26th April 2017

Application: 15/00837/OUT, Gavray Drive, Bicester

Proposal: 15/00837/OUT | OUTLINE - Residential development of up to 180 dwellings to include affordable housing, public open space, localised land remodelling, compensatory flood storage and structural planting. Part Land On The North East Side Of Gavray Drive Bicester

Gavray Drive East - Illustrative Masterplan  
Sketch of General Parameters  
1:2,000@A1 / 1:4,000@A3

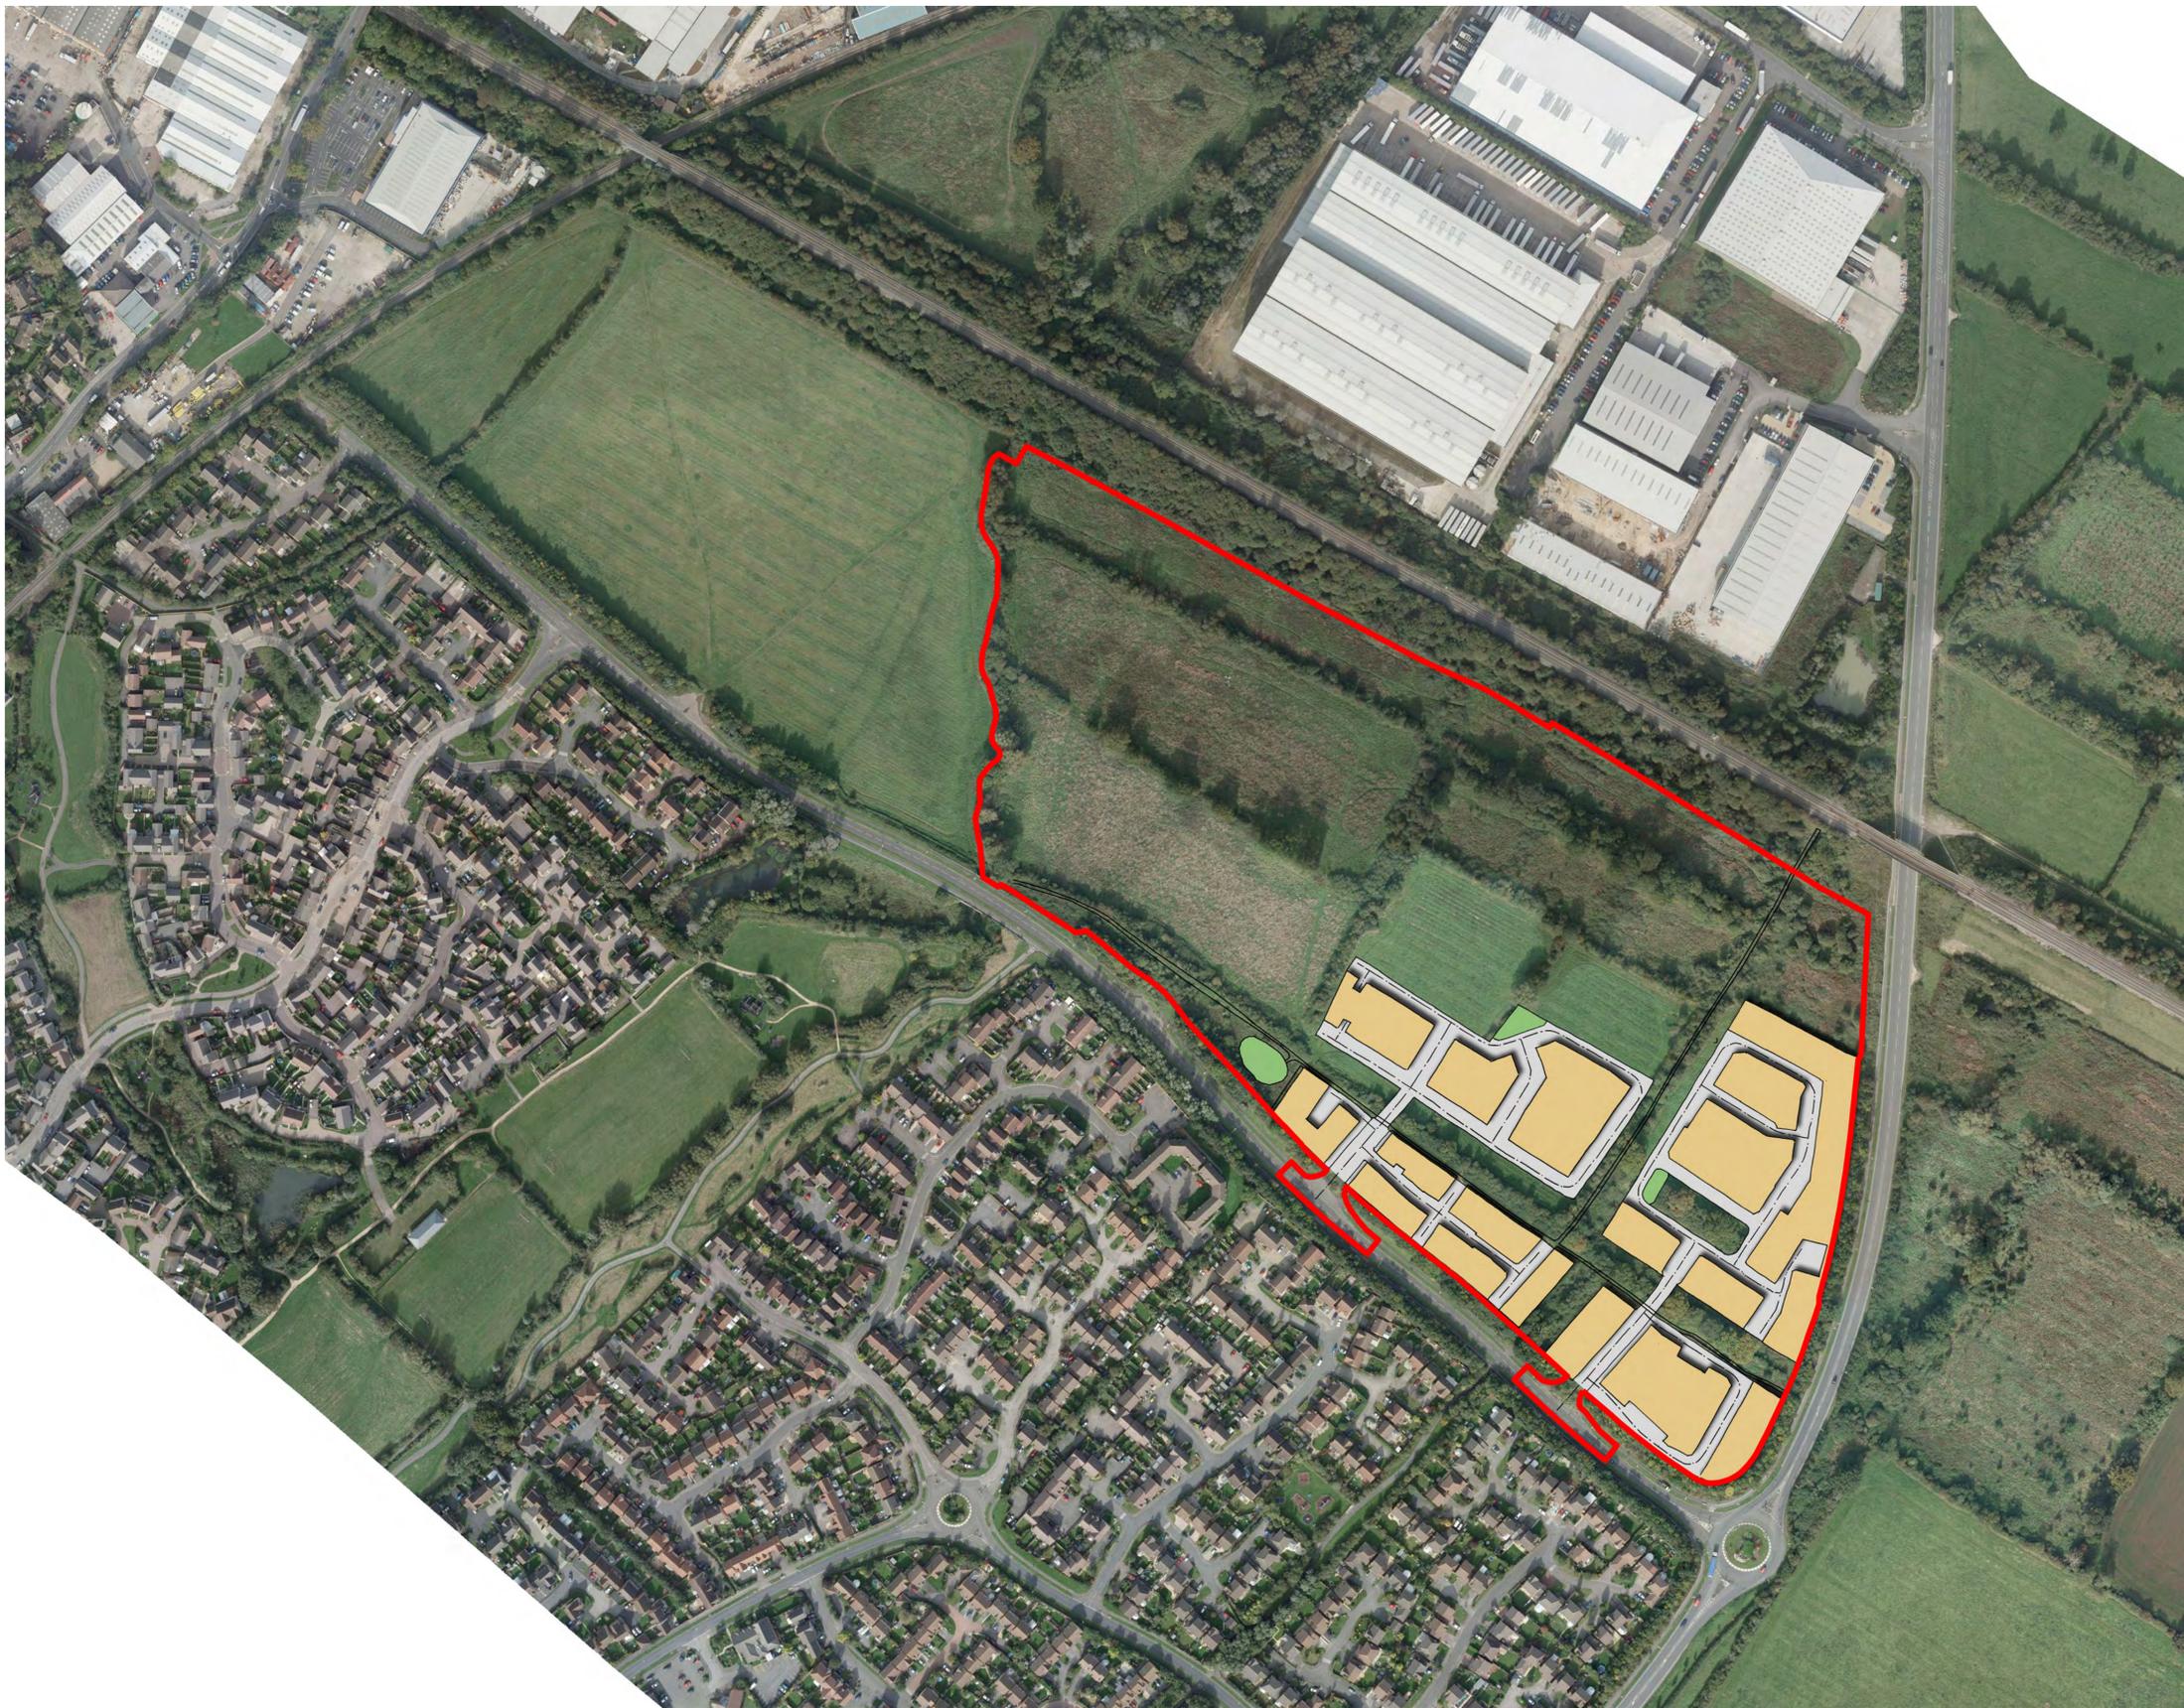
It is our understanding that this application is for 180 units on the western part of the site only. We are therefore surprised to see the submission of a drawing titled 'Gavray Drive East - Illustrative Masterplan' as part of this application, which suggests that a further phase of development is planned for the eastern part of the site. We are concerned that it is proposed for development to come forward in a piecemeal fashion with no holistic view being taken of

The Illustrative Masterplan for the eastern part also shows development coming right up to the LWS boundary. Being mindful of the LWS designation, its ecological interest and wider Green Infrastructure links we consider potential development in this eastern part of the site completely unacceptable in ecological terms.
